Rezoning Transportation Analysis

Petition Number: 2020-137

General Location Identifier: Tax ID 04922121

Date	Description
10-26-20	First Review
11-30-20	Second Review
12-28-20	Third Review
01-26-21	Fourth Review (WB)

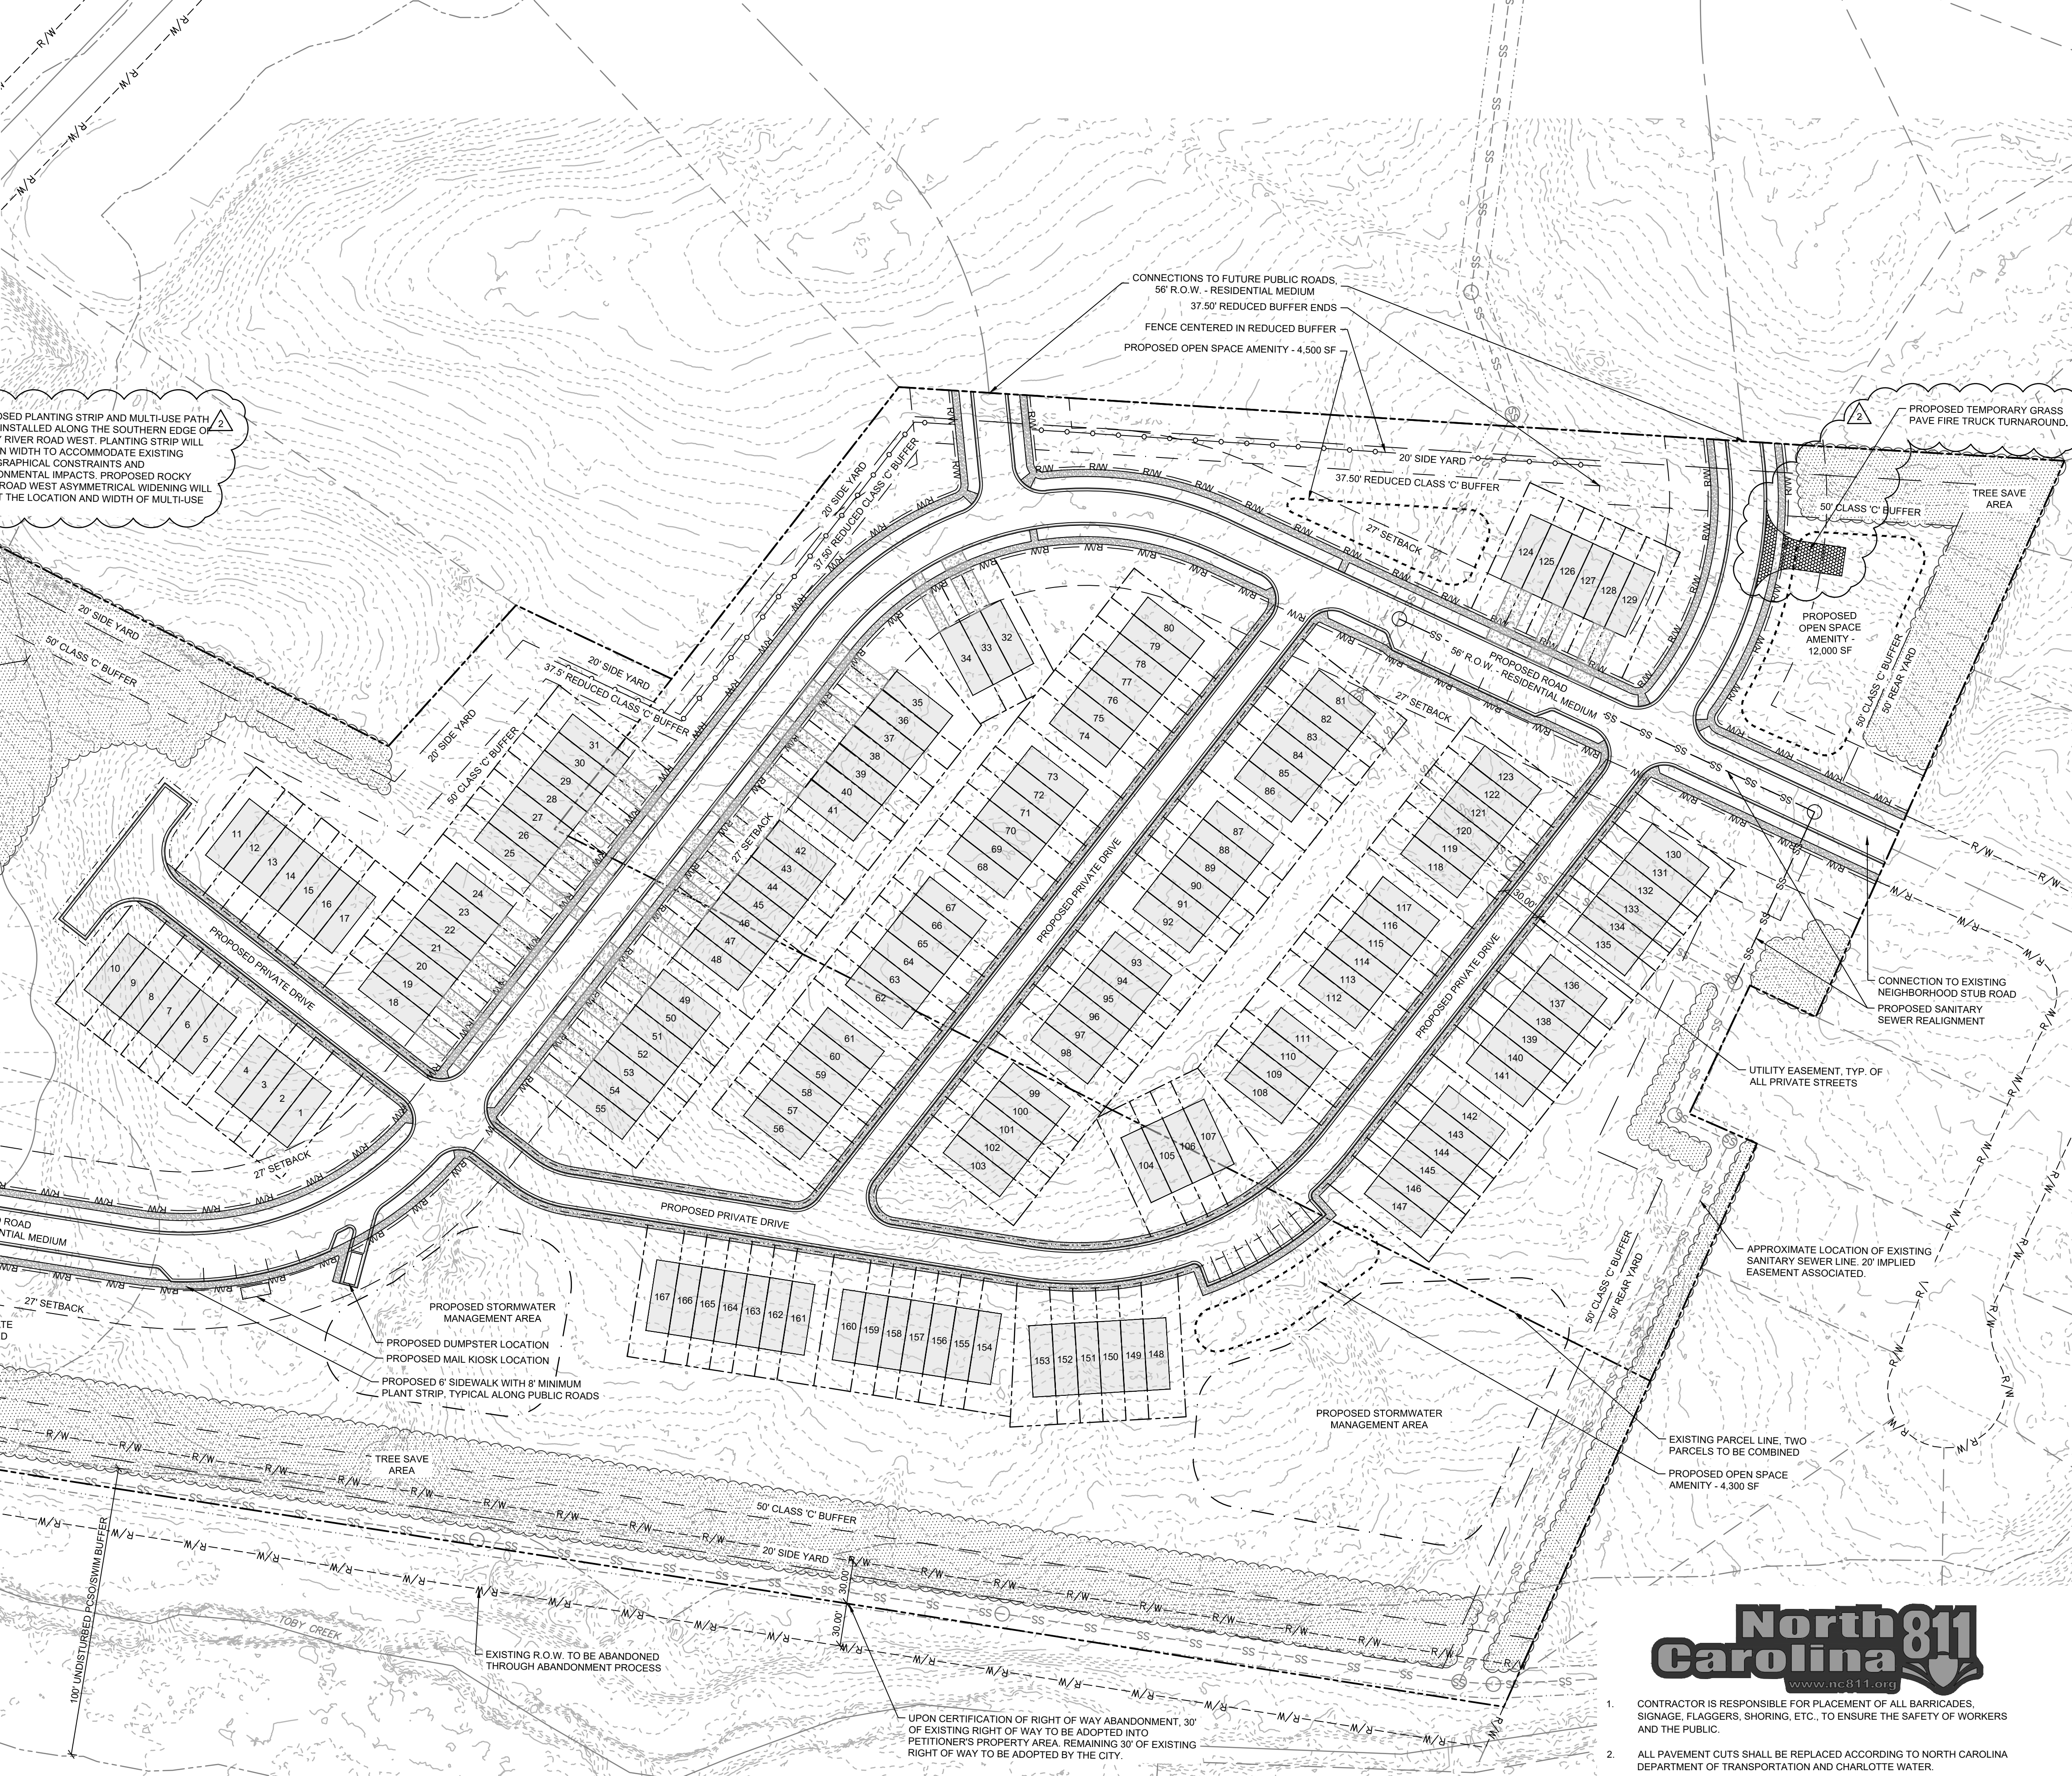
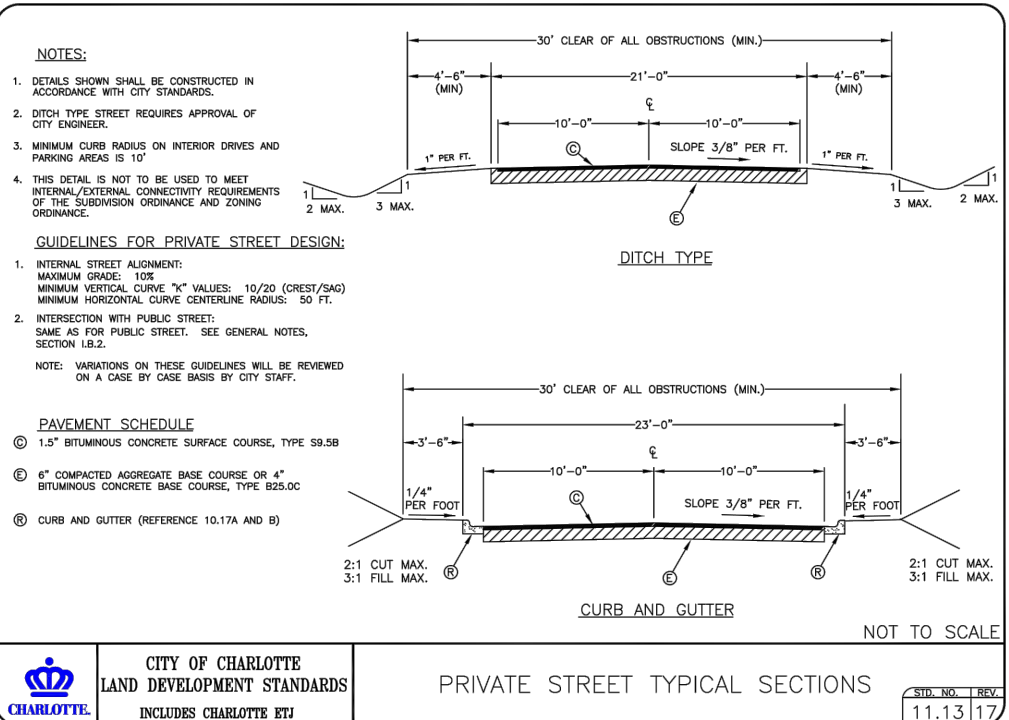
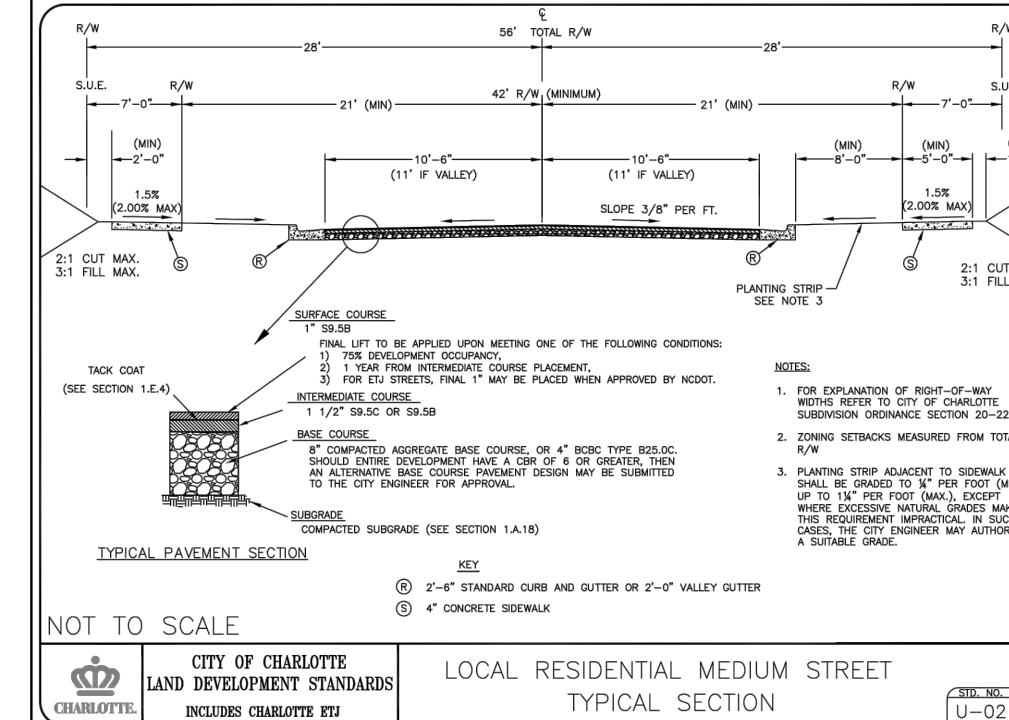
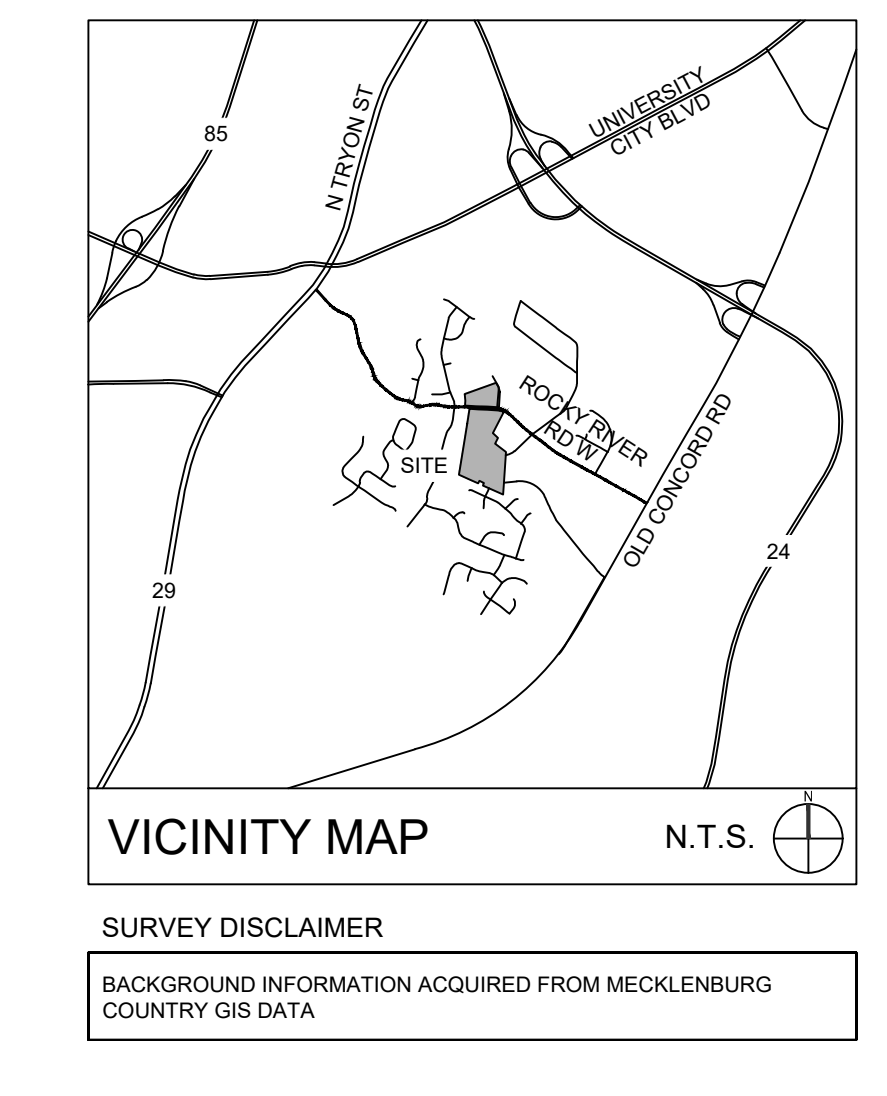
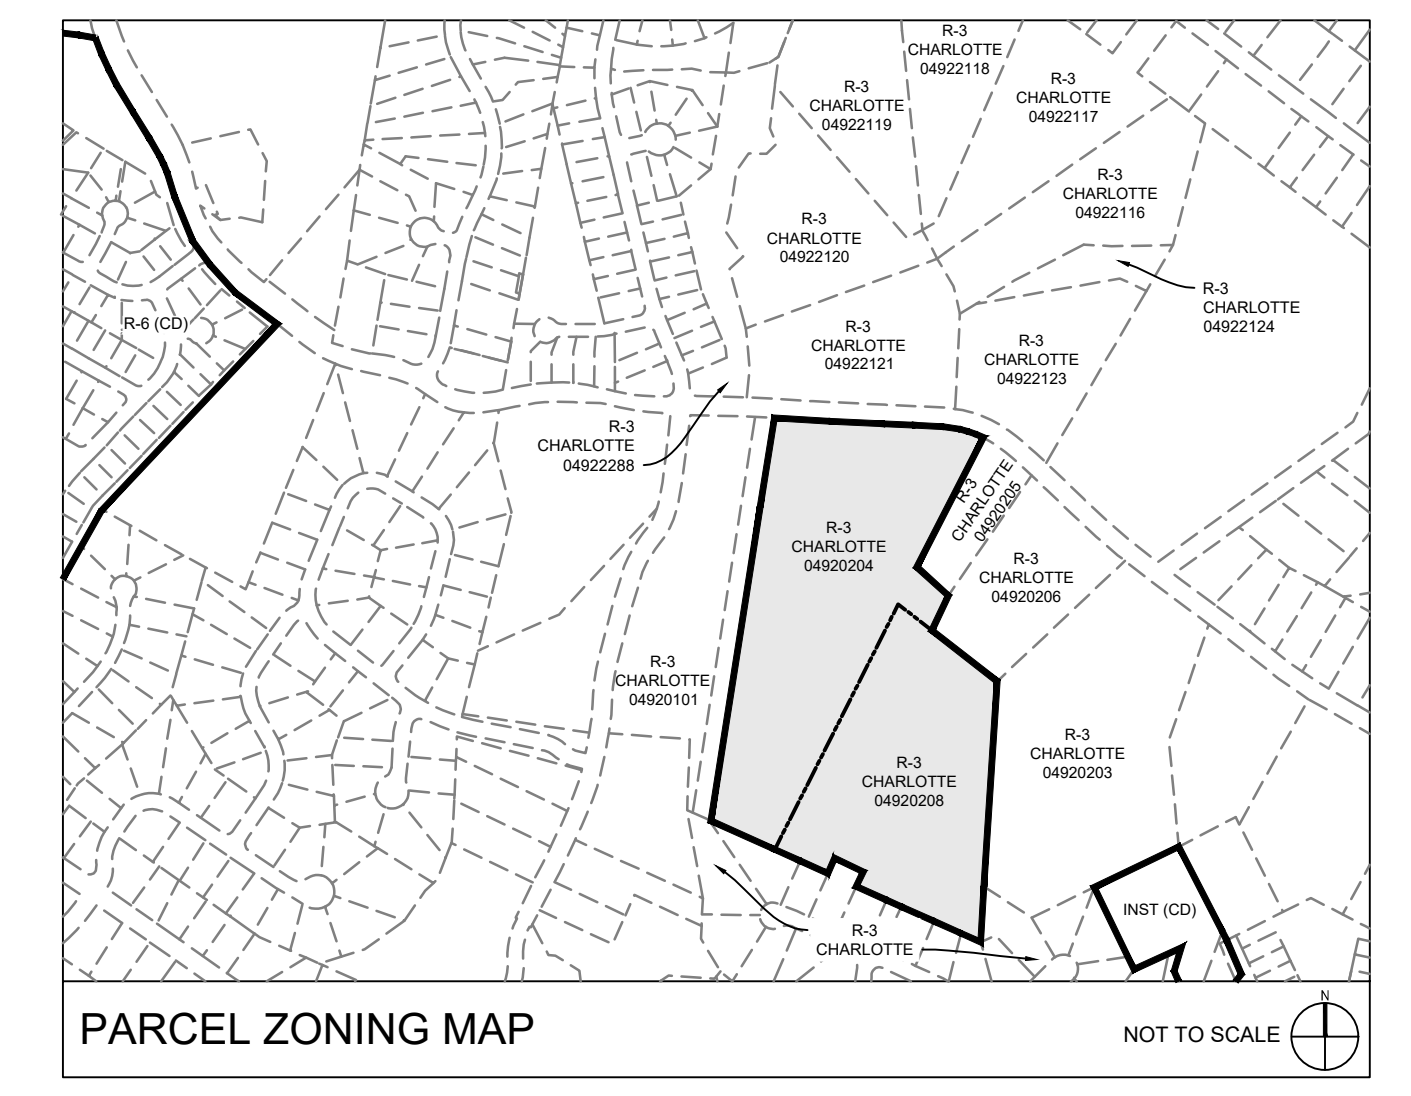
7. **(Comment Revision based on site plan submitted on 01-26-21)**

The petitioner did revise the site plan to provide a depiction of a pedestrian facility along the south side of Rocky River Road; however, the site plan and conditional note(s) need to be revised to explicitly commit to installing a 12' multi-use path (MUP) along property frontage. The petitioner shall label and

dimension the 12' multi-use path. All references to a variable width planting strip should also state that the minimum allowable planting strip will be 4 feet.

DEVELOPMENT STANDARDS AND THE ORDINANCE, ARE SUBJECT TO MINOR ALTERATIONS OR MODIFICATIONS DURING THE DESIGN DEVELOPMENT AND CONSTRUCTION DOCUMENT PHASES		2. PITCHED ROOFS THAN 5:12, EXCEPT NO LESS THAN EMPLOYED.
Add a conditional note committing to the installation of a 12' multi-use path along property frontage to provide connectivity and accessibility in accordance with the City of Charlotte BIKE and Charlotte WALKS policies.		3. DUMPSTER AND SOLID WALL OR BE COMPATIBLE
